February 1, 2018

**RE: Fontaine Boulevard and East Fork Jimmy Camp Creek at Lorson Ranch,
Final Design. El Paso County, Colorado (Kiowa Project No. 16031)**

**CDR-16-009 Lorson Ranch East, East Fork Jimmy Camp Creek Drainageway
and Fontaine Boulevard Bridge Design- Final Submittal**

**LORSON RANCH**  
**FONTAINE BOULEVARD BRIDGE AND CHANNEL DESIGN**  
**GRADING PLAN & EROSION CONTROL PLAN**  
EL PASO COUNTY, COLORADO

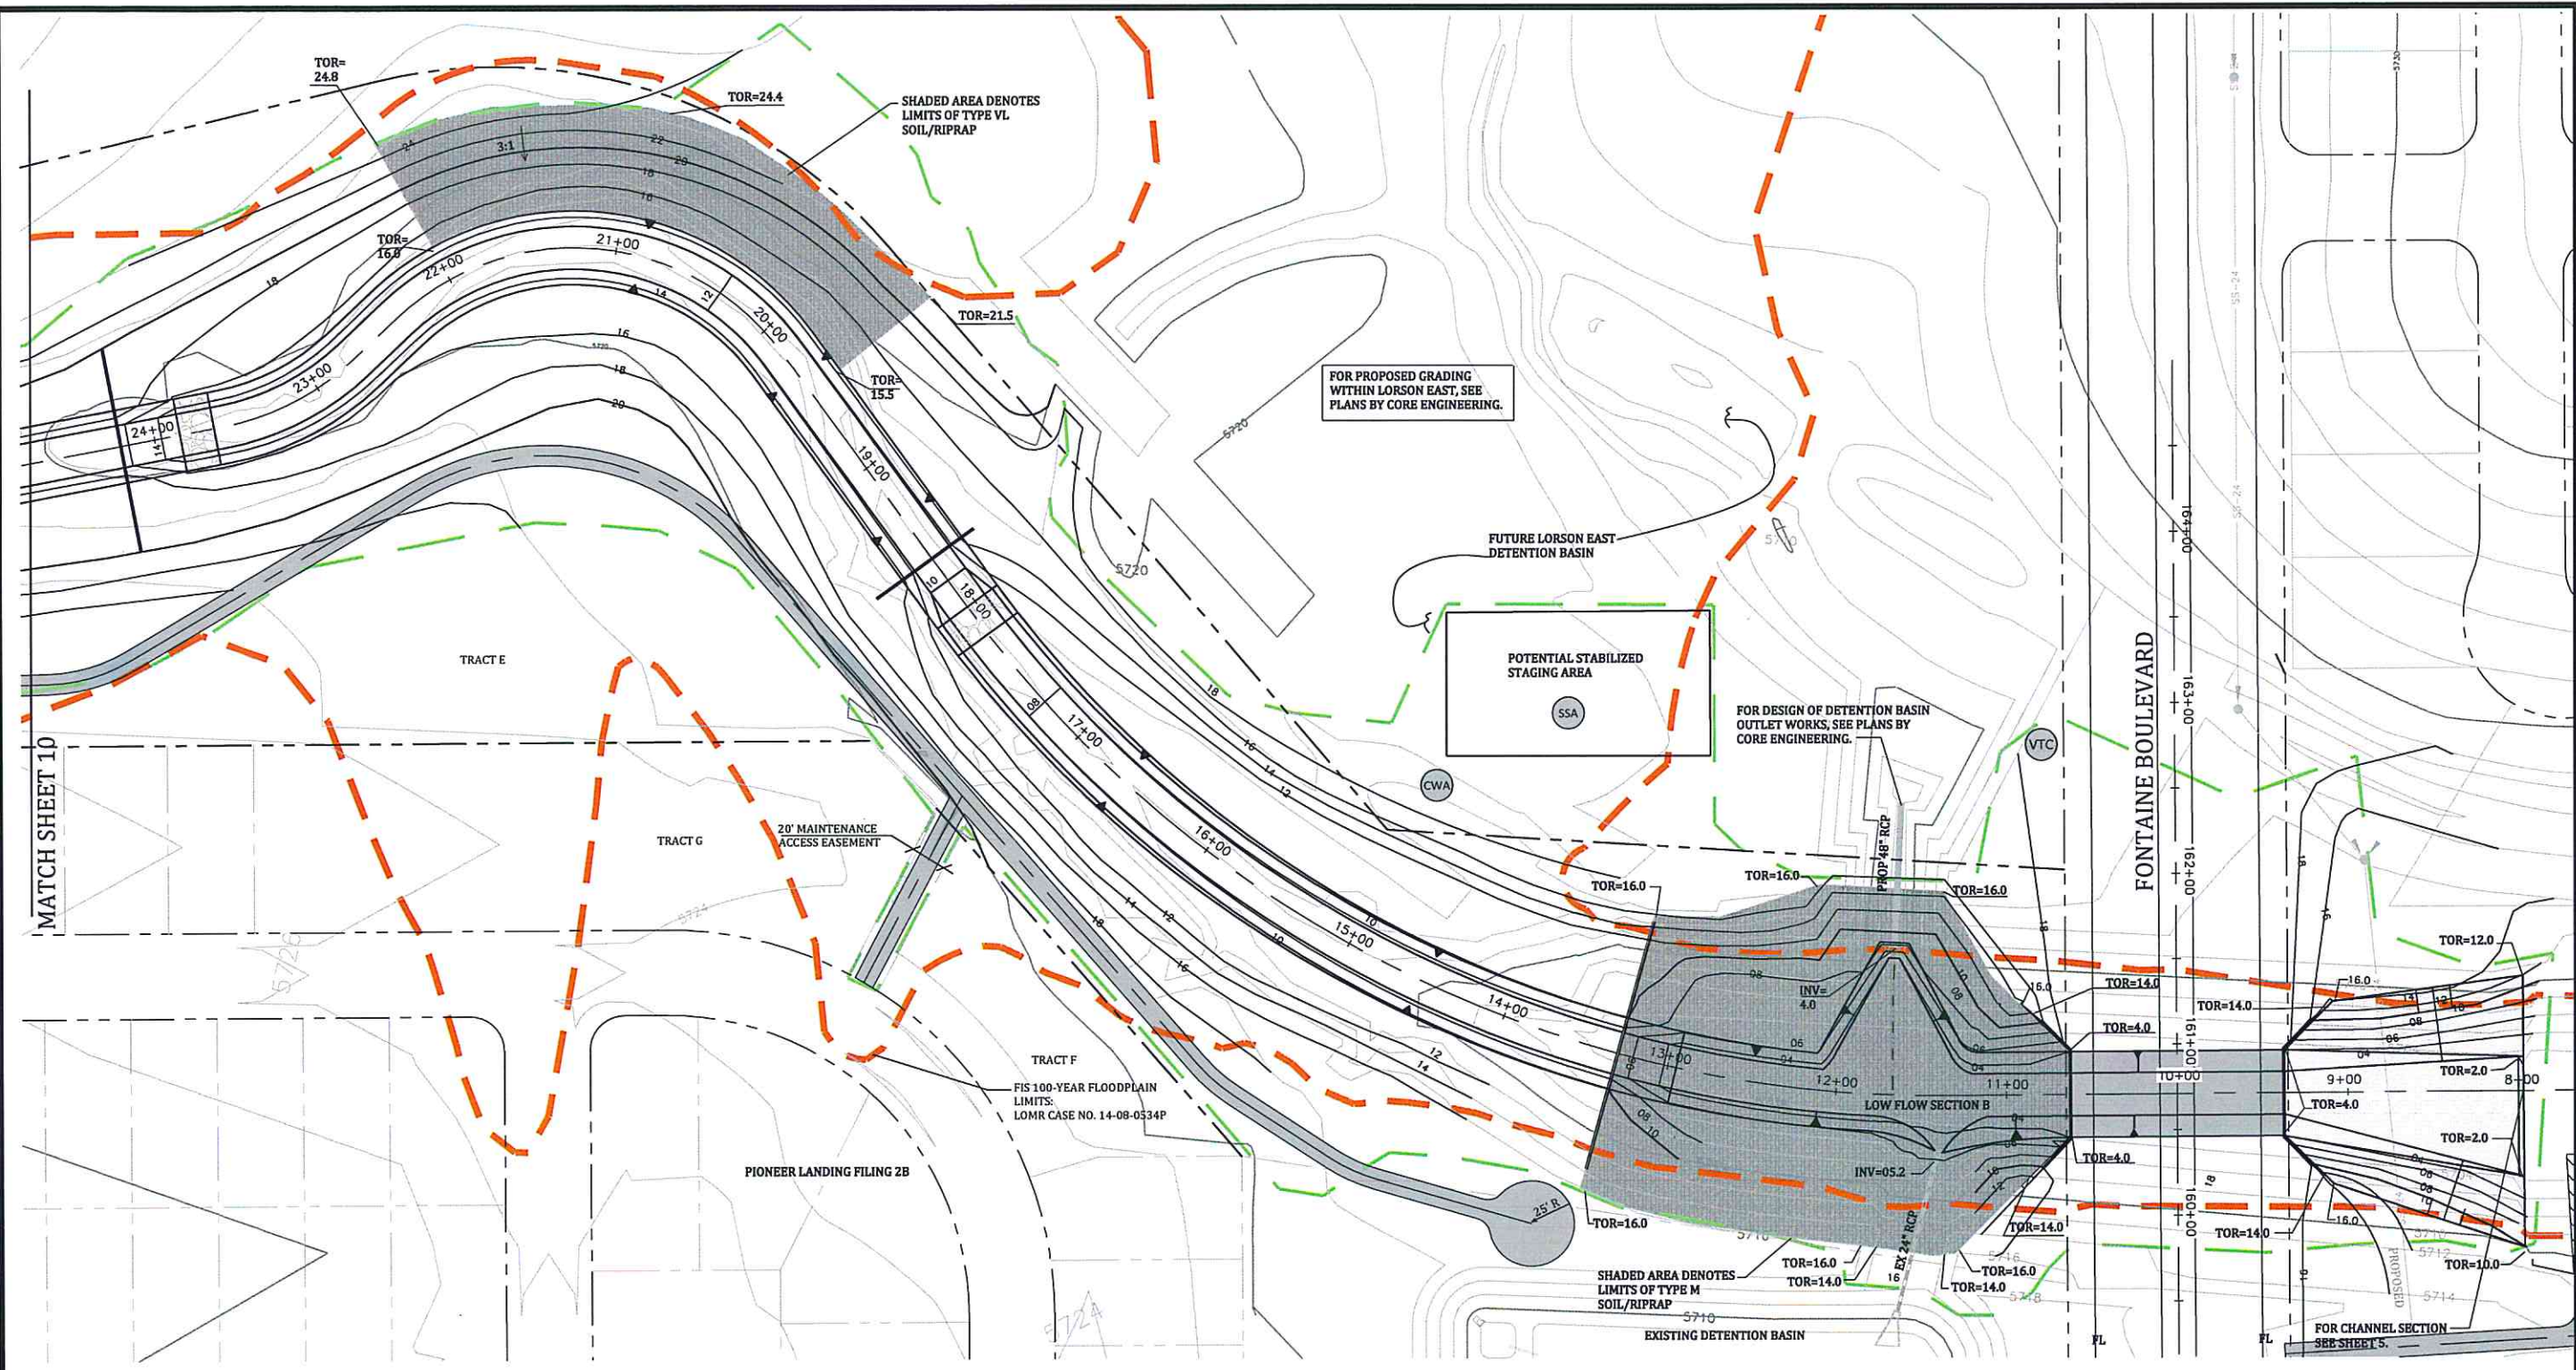
1. Resolved: Maintenance access to south side of Fontaine bridge has been added to the plans.
2. Resolved
3. a. Resolved.
b. Line types for lot lines has been revised.
c. Resolved
4. Resolved
5. Comment noted.
6. SWMP has been revised per the County's latest comments.
